RE: SUBMISSION TO SSD-88004956

Thank you for the opportunity to comment on State Significant Development (SSD) application (**SSD-88004956**) for redevelopment of the Lourdes Retirement Village, including refurbishment of the existing residential care facility and construction of new independent living unit buildings with resident facilities at 95-97 Stanhope Road, Killara.

Ku-ring-gai Council's objection to SSD-88004956 at 95-97 Stanhope Road, Killara.

Figure 5 Bushfire overlay on the proposed development

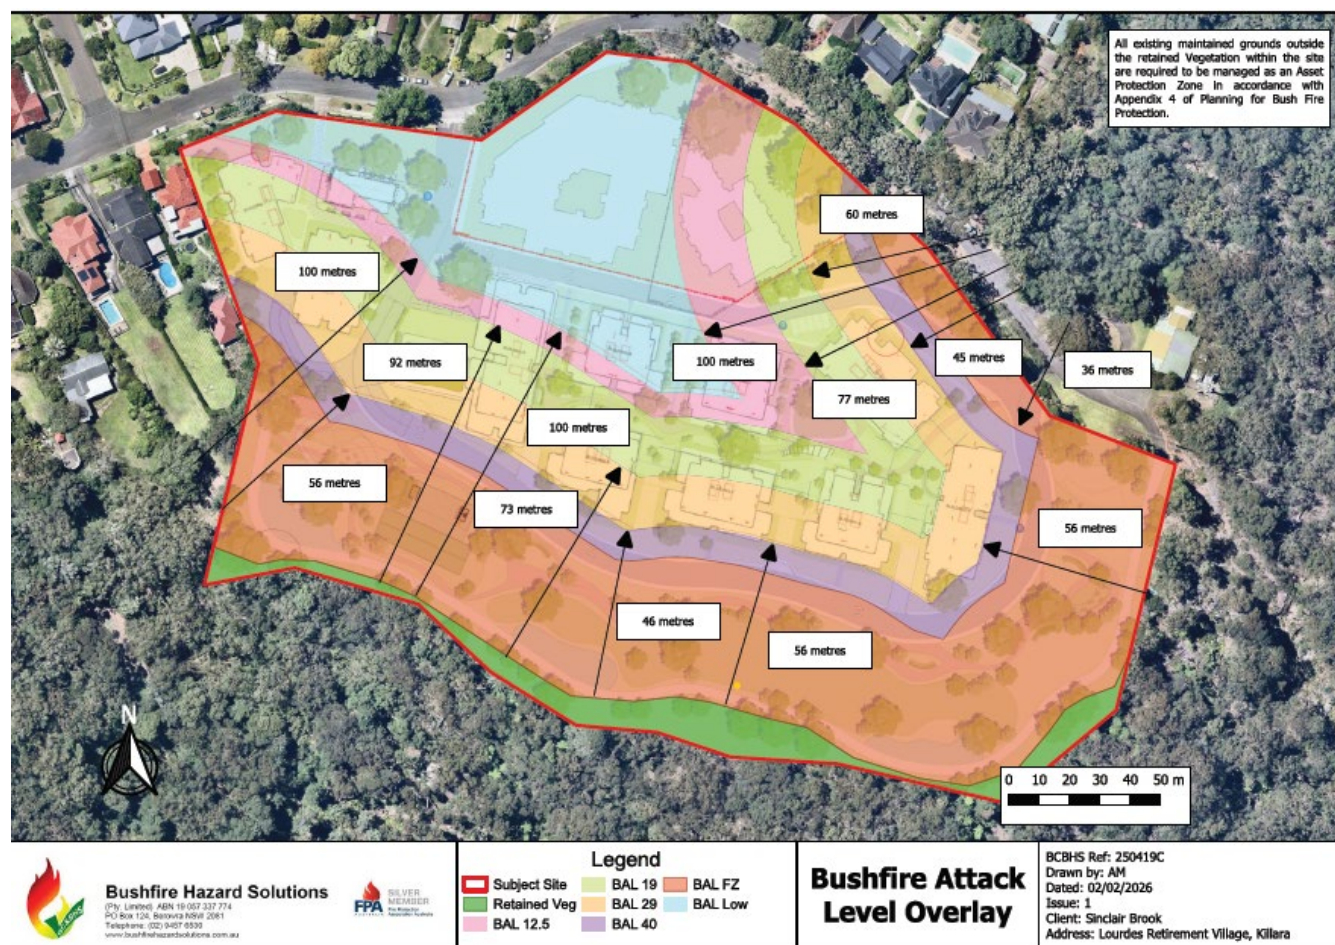
radiant heat levels of greater than 10kW/ m² (calculated at 1200K) will not be experienced on any part of the building. However, Figure 10 of the consultants report (p.25) demonstrates that the majority of building footprints are in BAL 19, BAL 29 – and even some building fronts/corners in the BAL 40 zone. Such an arrangement of structures in the 60m to 100m sector (distant from the hazard) means that radiant heat impacts will be far more excessive than the required <10/KWsqm (bold emphasis added). Most structures may experience radiant heat levels of 19-29KW/sqm. As previously discussed within **Attachment 2**, Councils view is that predicted higher radiant heat impacts could be experienced.

- At page 25 within the Bushfire Assessment Report it shows, within Figure 10, a BAL Overlay showing proposed building locations. The figure indicates that most building footprints are in BAL 29 and BAL 19 zones, which are still high ember attack areas, with protection needs. Our view is that, if the proposed arrangement of building footprints were considered acceptable in terms of PBP 2019, then the ‘edge’ building footprints in the sectors outlined in black (below) should either be built to BAL 40 specifications – or the footprints should be retreated fully into the BAL 29 zoning.
